**KIRKLEES METROPOLITAN COUNCIL
INVESTMENT & REGENERATION SERVICE**

**DELEGATED DECISION TO DETERMINE APPLICATIONS FOR
CONSENT, AGREEMENT OR APPROVAL REQUIRED BY CONDITION**

Reference No:	2023/44/90915/E
Site Address:	adj, 115, Westfield Lane, Wyke, BD12 9LY
Description:	Discharge of conditions 6, 7, 8, 9, 10, 11, 12, 13, 14, 15, 16, 18, 19, 20, 21, 22, 23, 25, 27, 28, 30, 31, 32, 33, 34 and 36 of previous permission 2023/91472 for the variation of conditions 9, 11, 12, 22, 23, 25, 27, 29, 30, 33, 34 and 38 of previous outline permission 2020/90436 for the demolition of one dwelling and erection of residential development and associated works with details for access
Recommending Officer:	Callum Harrison

DECISION – Discharge of Conditions – Split Decision

SITE PLAN
(1:250)

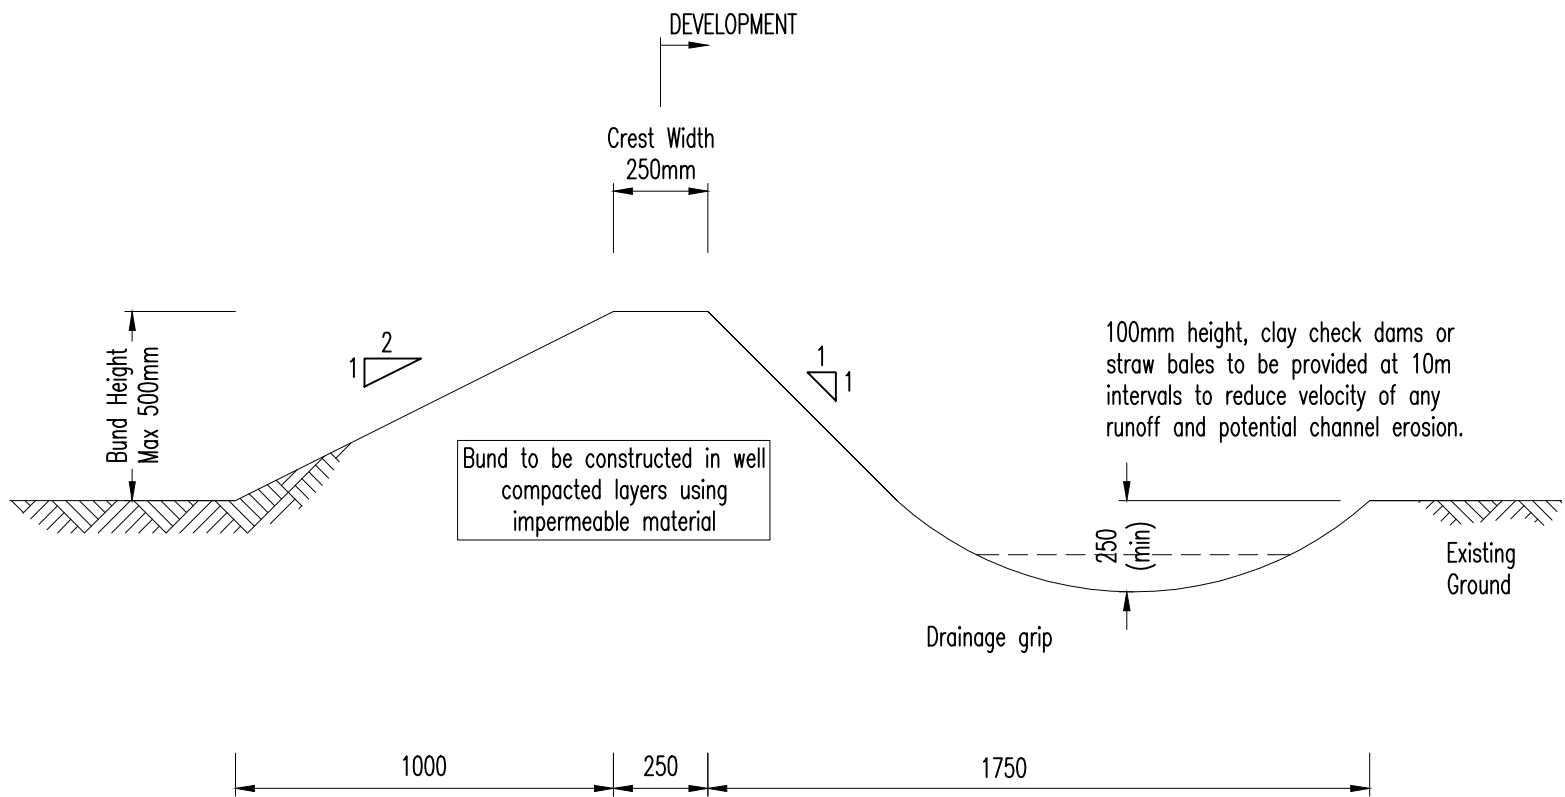
KC LLFA have reviewed these documents. They deem that the proposed temporary surface water drainage system is sufficient to prevent flooding and drainage issue during construction. As such, **an approval pursuant to condition 9 can be issued for the purposes of this pre-commencement condition, however works must be carried out in accordance with the approved details.**

SECTION A-A
THROUGH CONTROL
MANHOLE
(1:20)

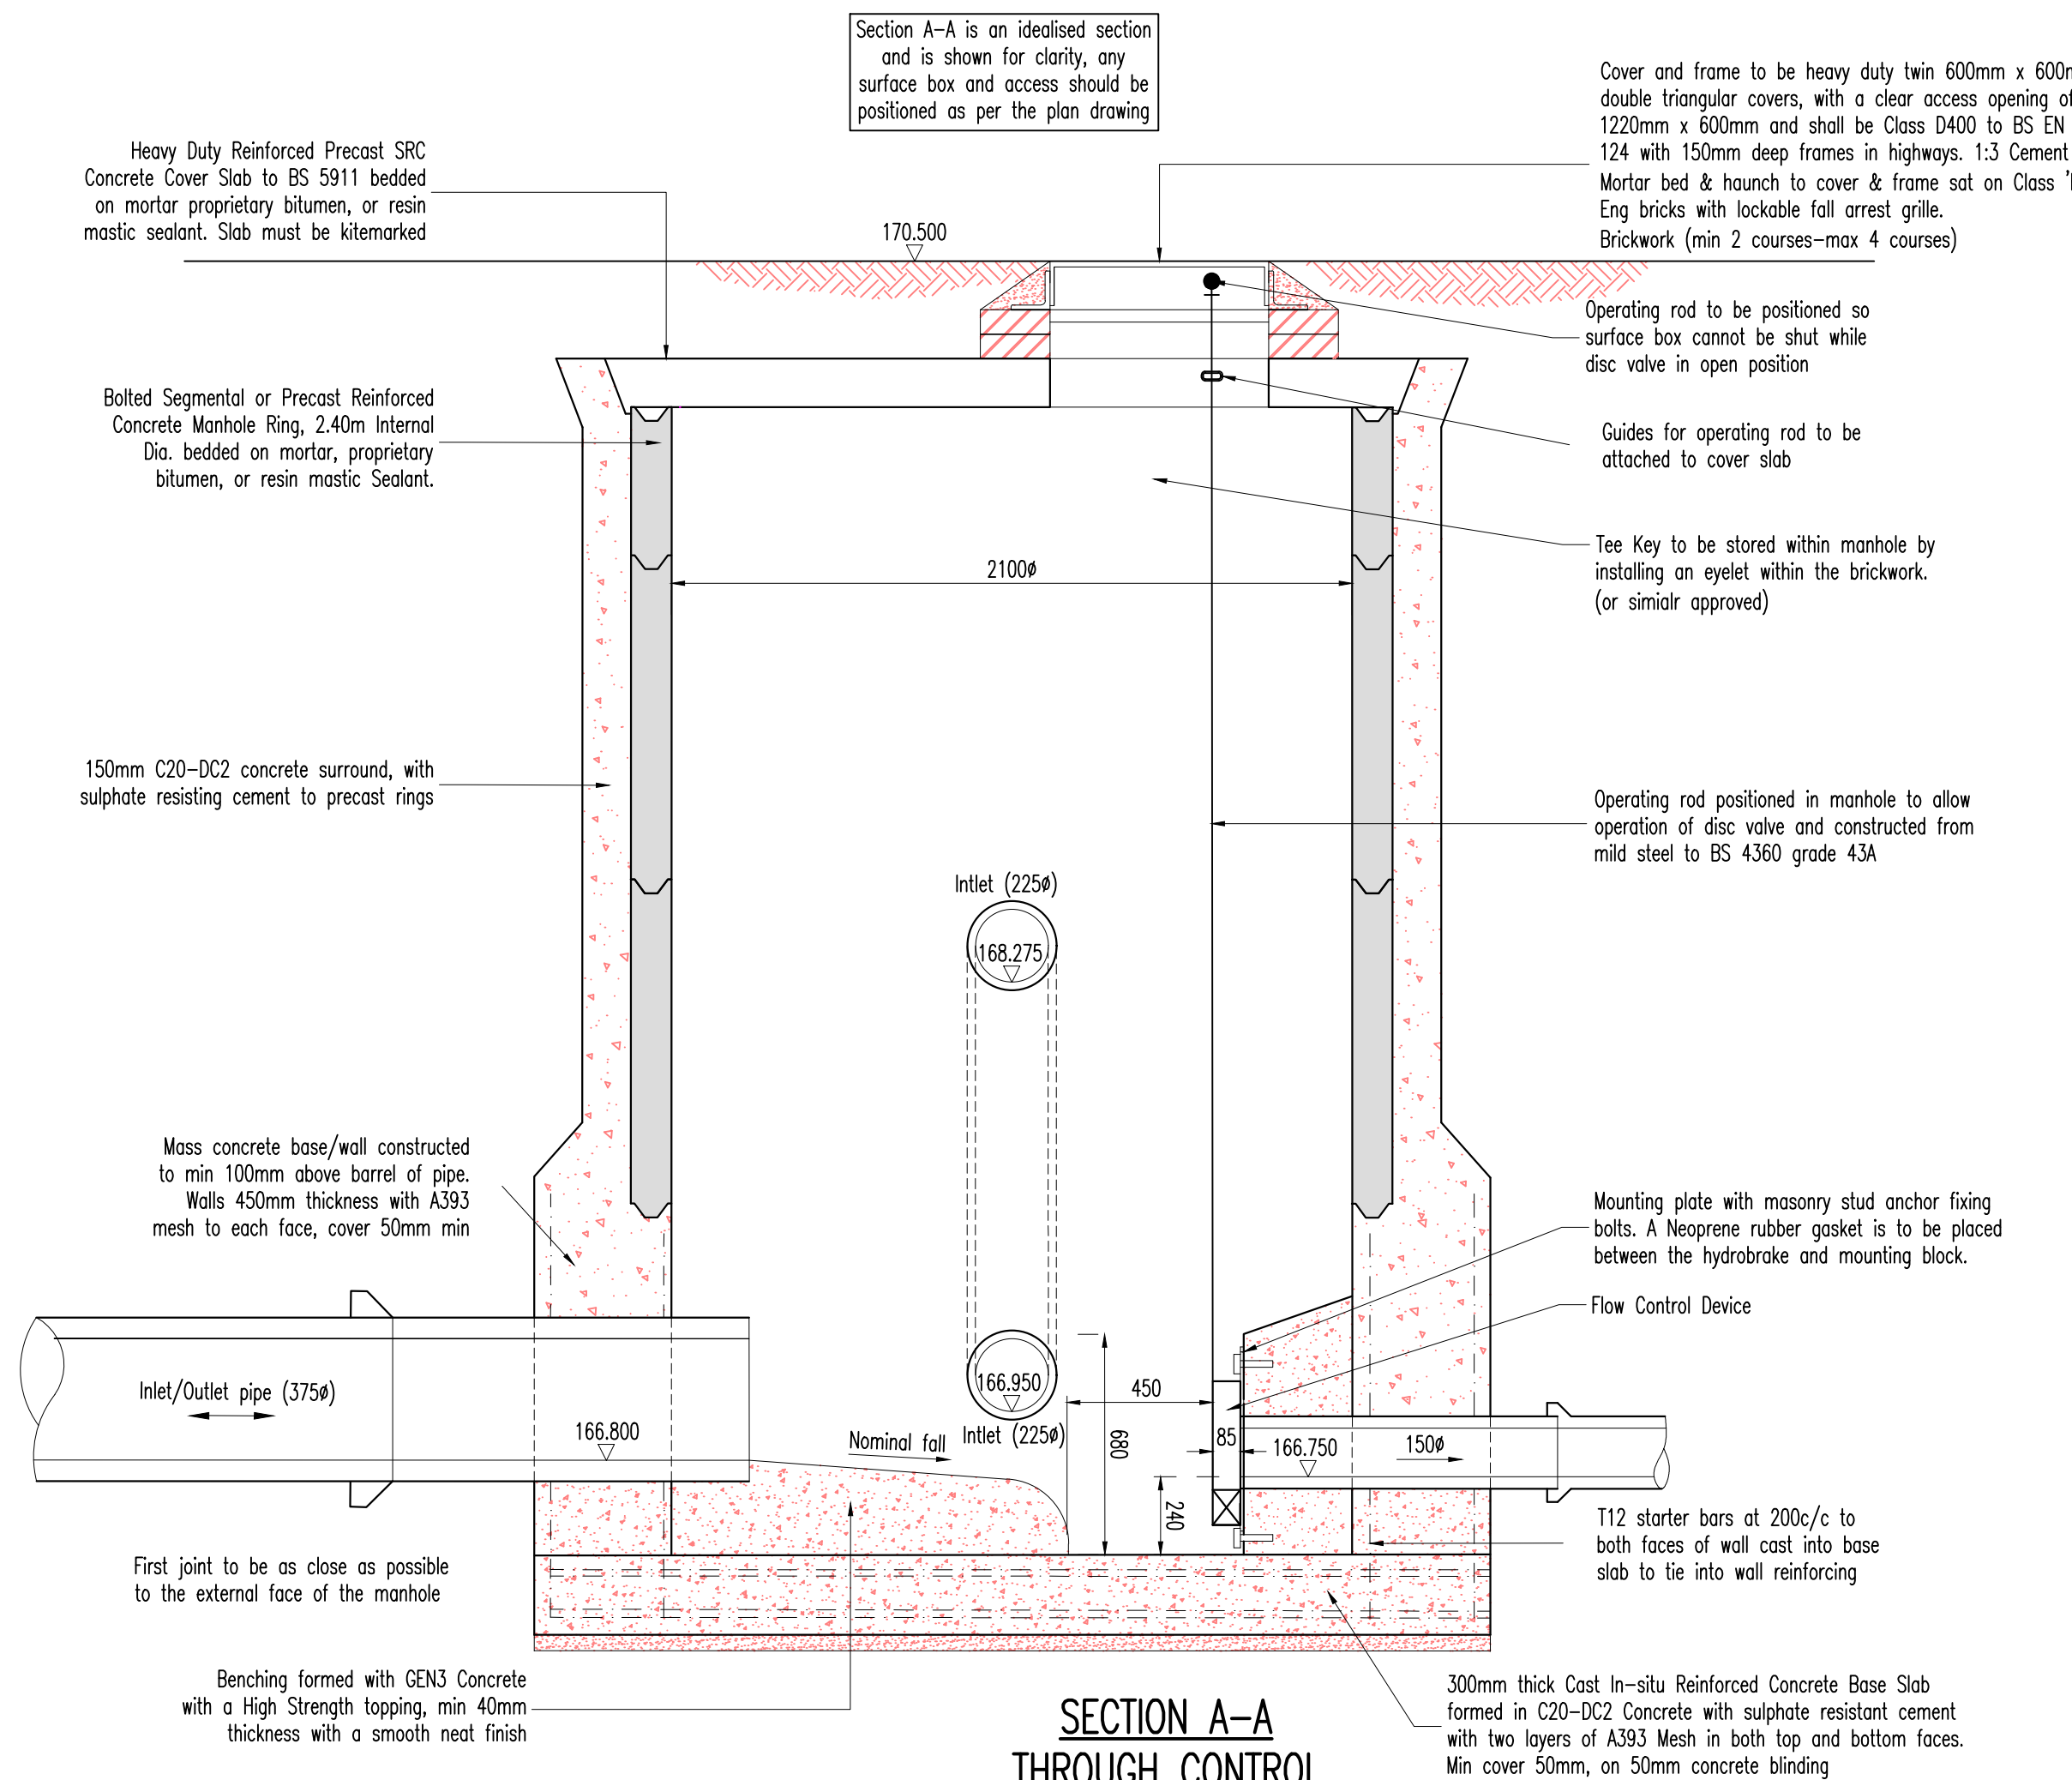
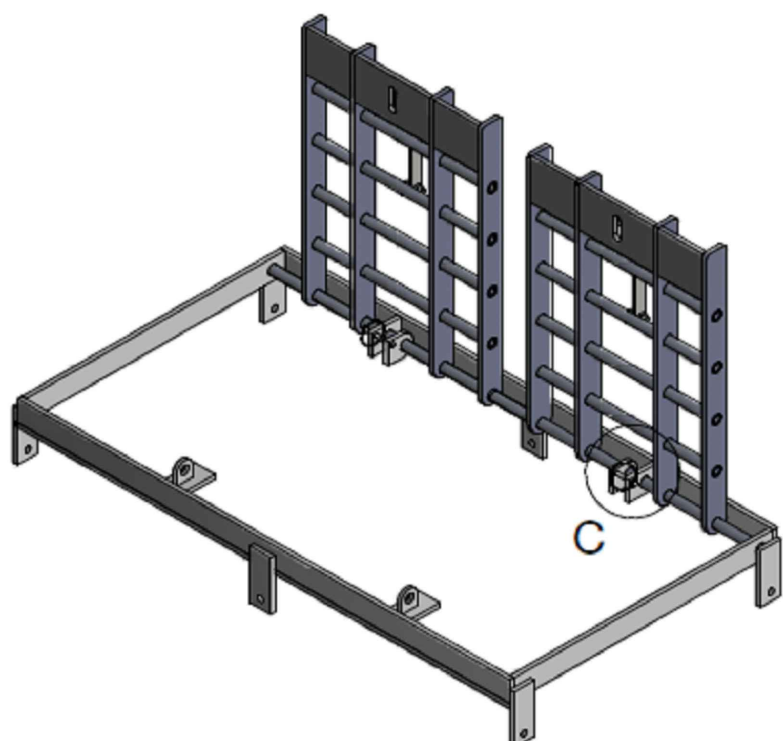
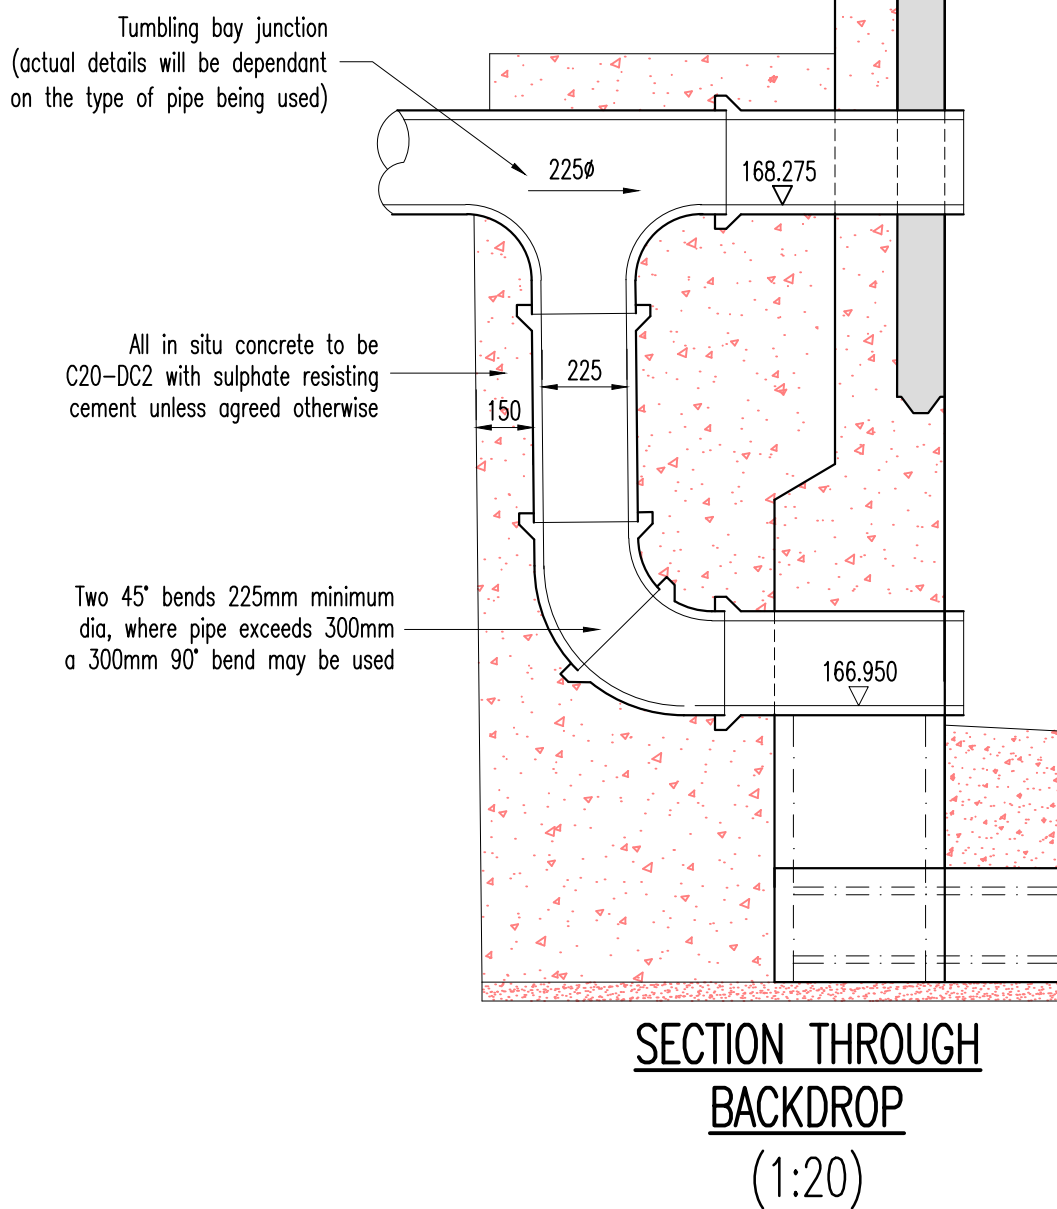
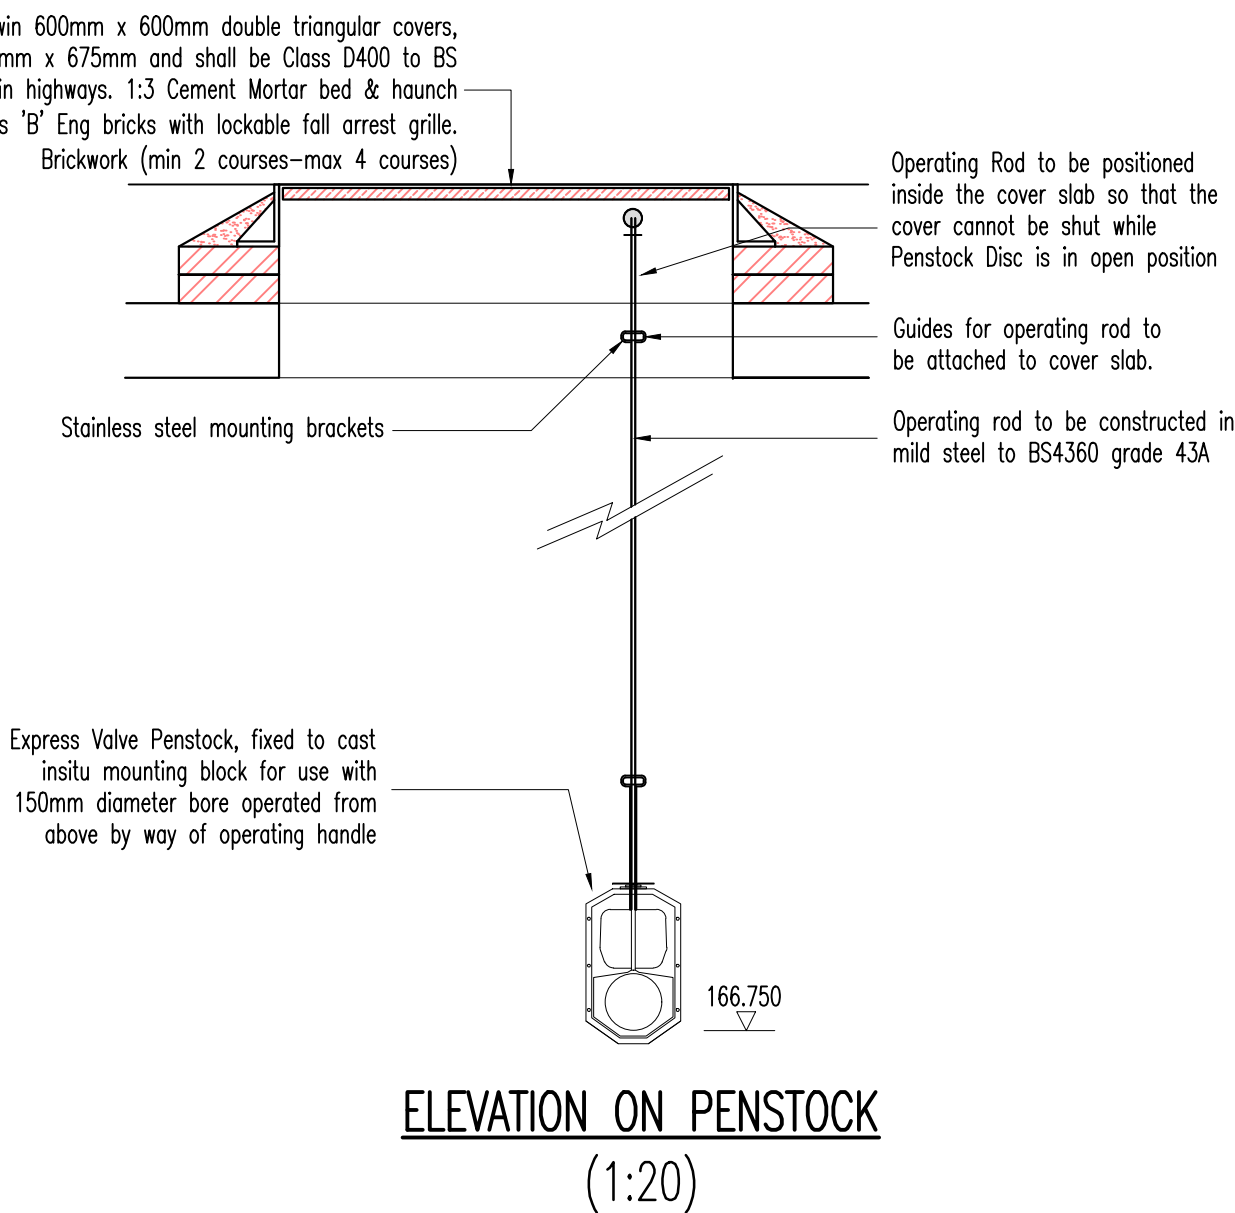
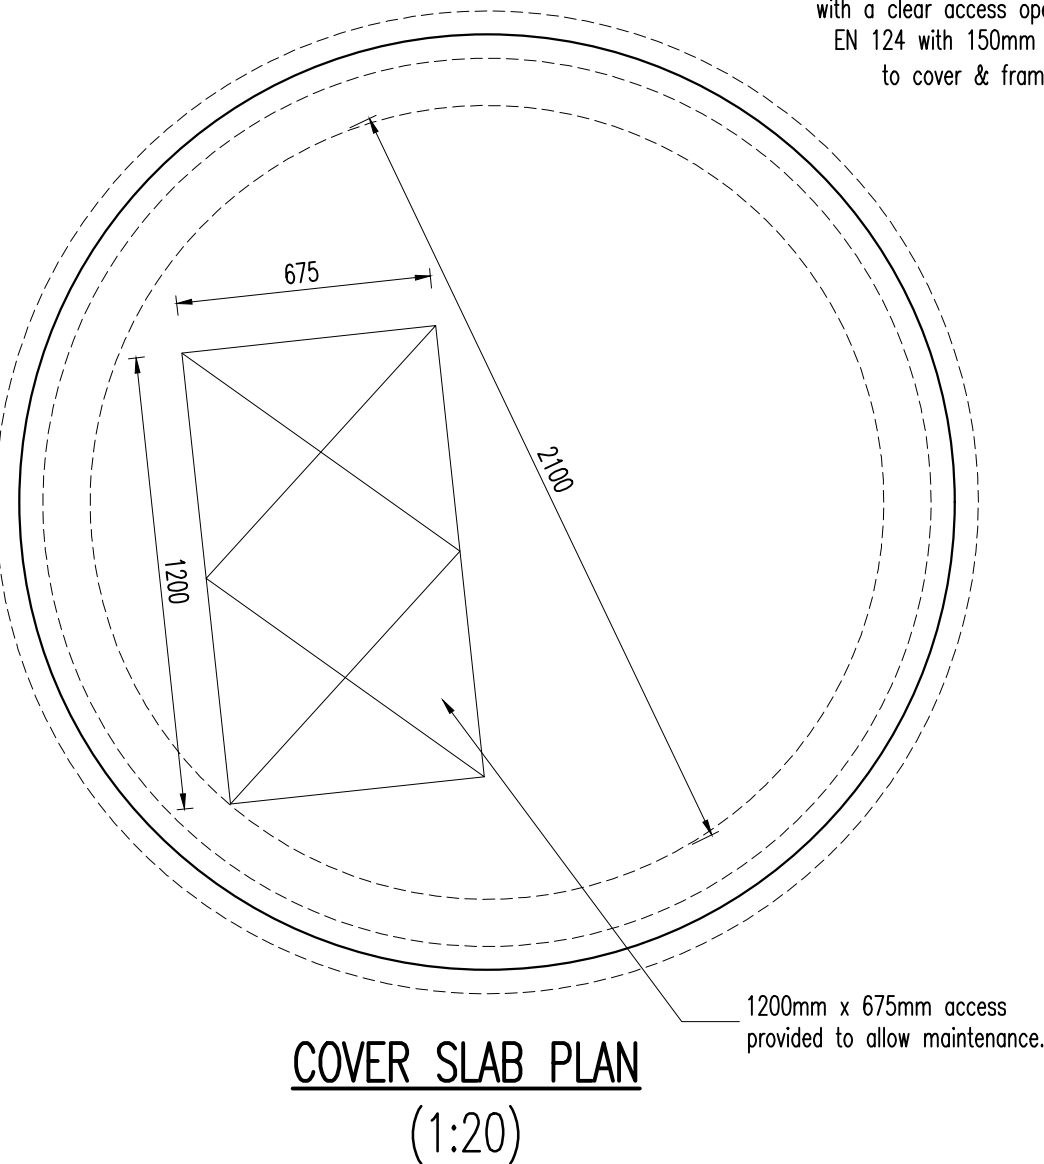
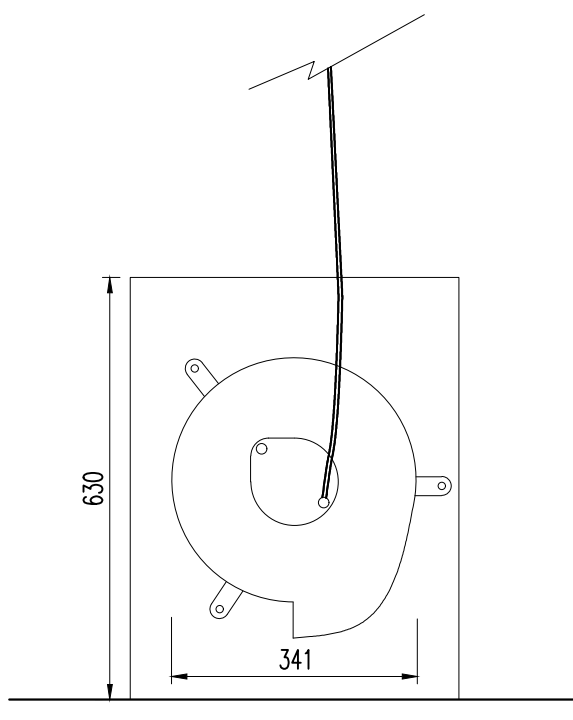
The tank design on the submitted plans is generic and does not reflect that in MicroDrainage, a plan can cross section of the selected final design needs to be submitted to complete this application. The contributing areas within MicroDrainage simulations should reflect those on the impermeable area diagram which they currently do not do. Also, details of the proposed foul drainage are required. As such **condition 7 cannot be discharged at this time.**
